Merewether High School

14 December 2021

**Newcastle Jockey Club New Stables Complex (SSD-12982045) – 125 Chatham Street,
Broadmeadow NSW**

Appendix 2 – Heavy Vehicle Detour Map

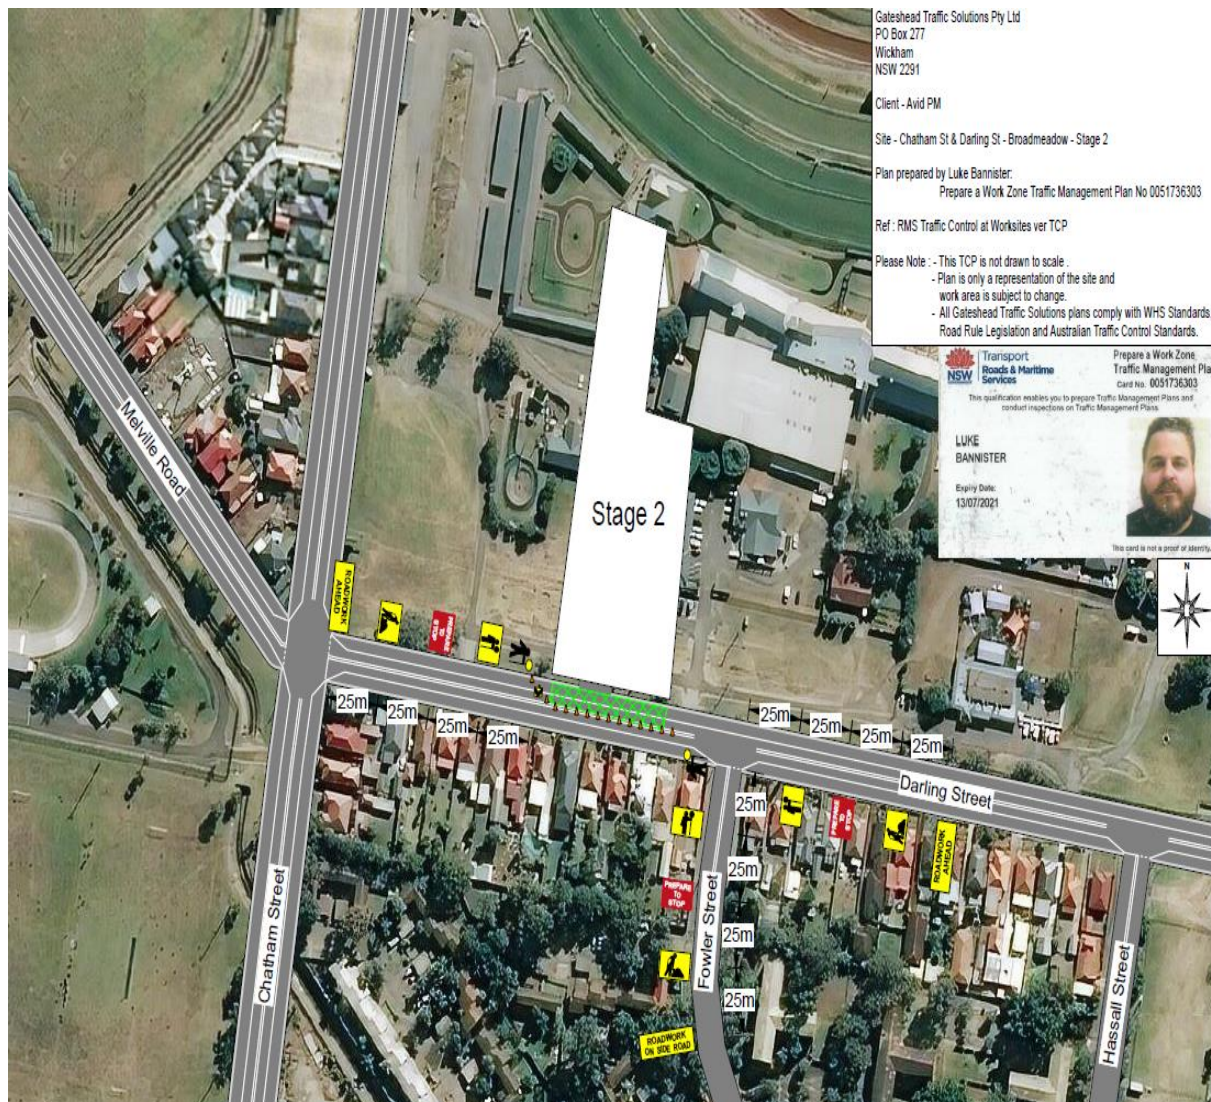
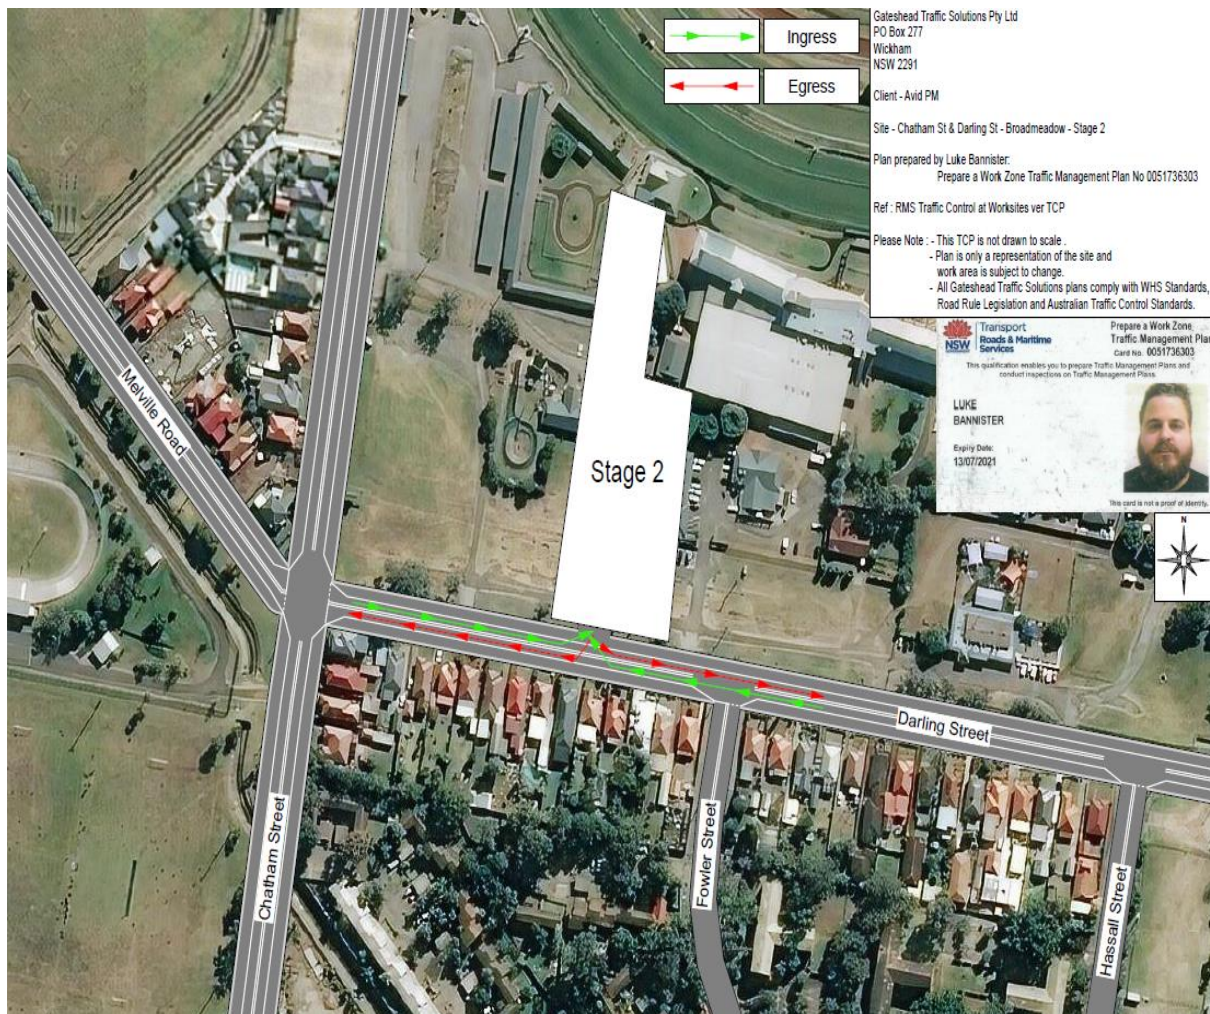
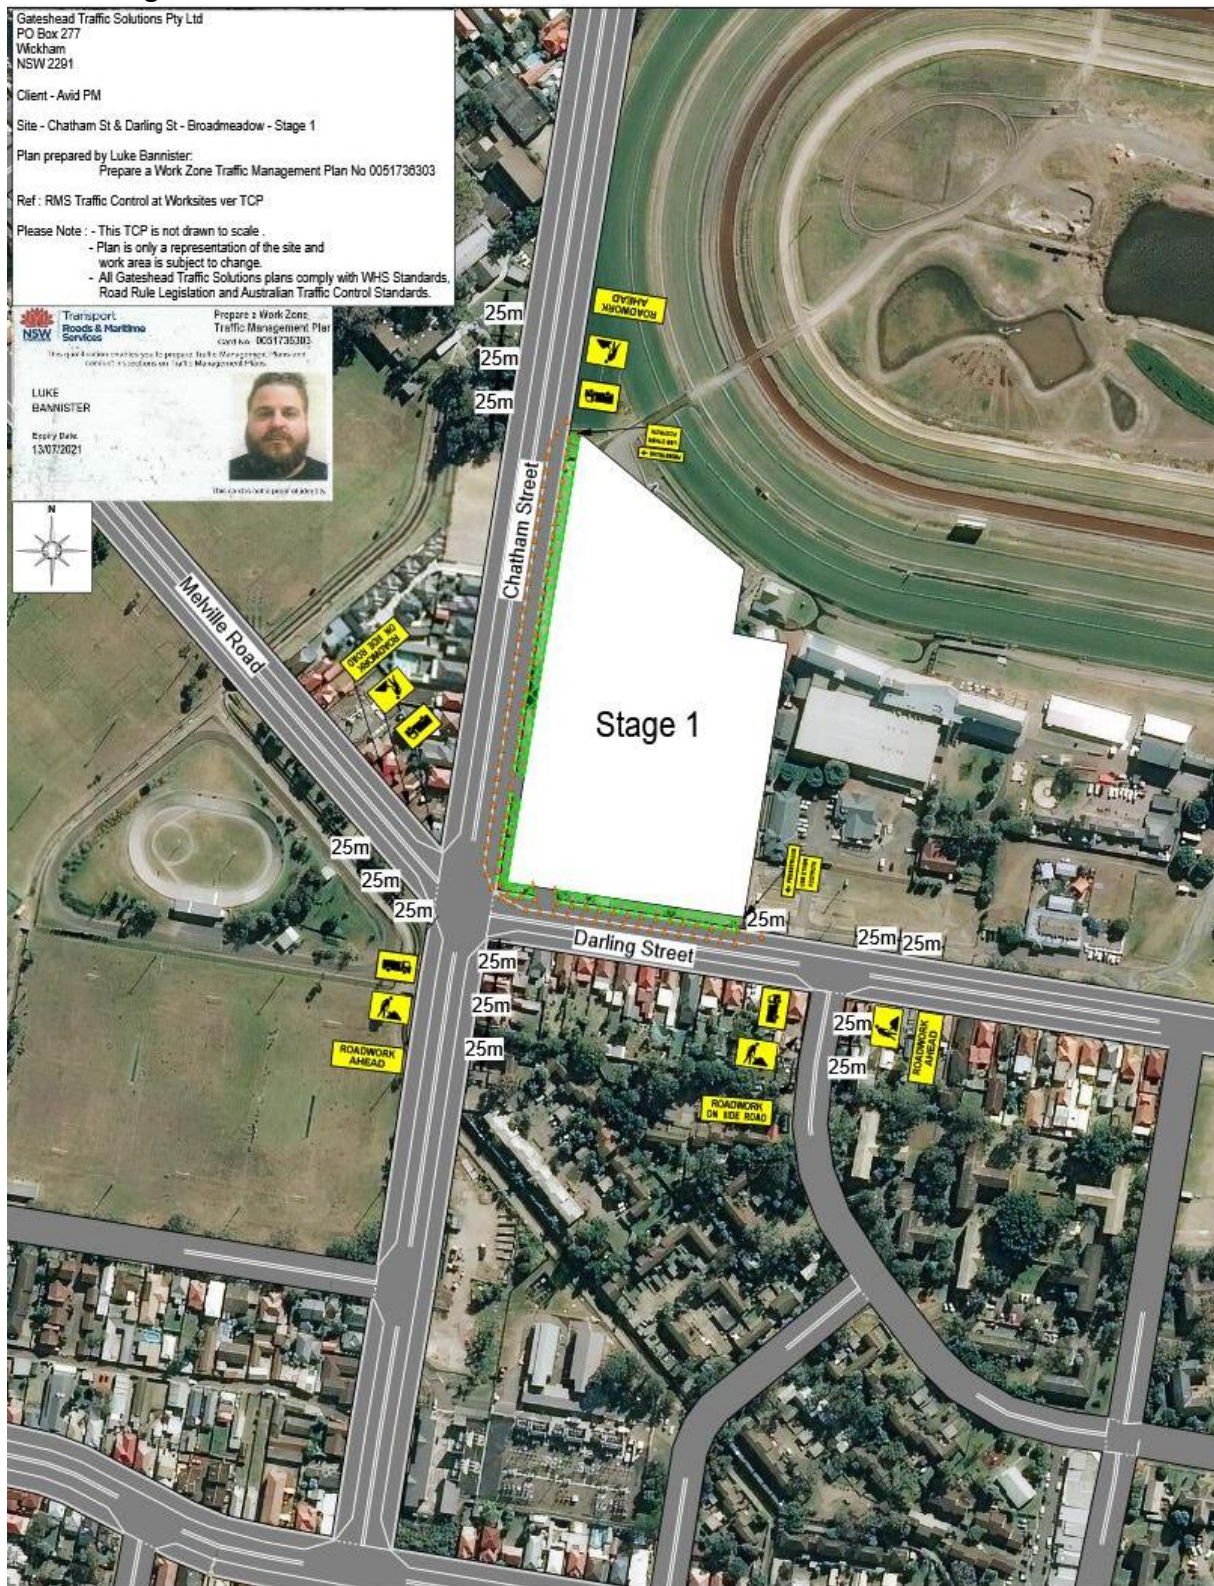
However, Appendix 3 “Pedestrian Detour Map” shows that part of the road on the NJC side of Chatham Street will be closed off to allow for construction and that pedestrians will be detoured onto the side of the road where cars would otherwise be parked.

Stage 1 – the proposal is for heavy vehicles to enter via Chatham Street and exit via Darling Street.

There are currently two access gates from Chatham Street into the NJC – one is approximately 60 metres away from the school road crossing (towards Darling Street) and the other entrance is the current car park entrance.

A full assessment of traffic management which includes the safety of the school and community.
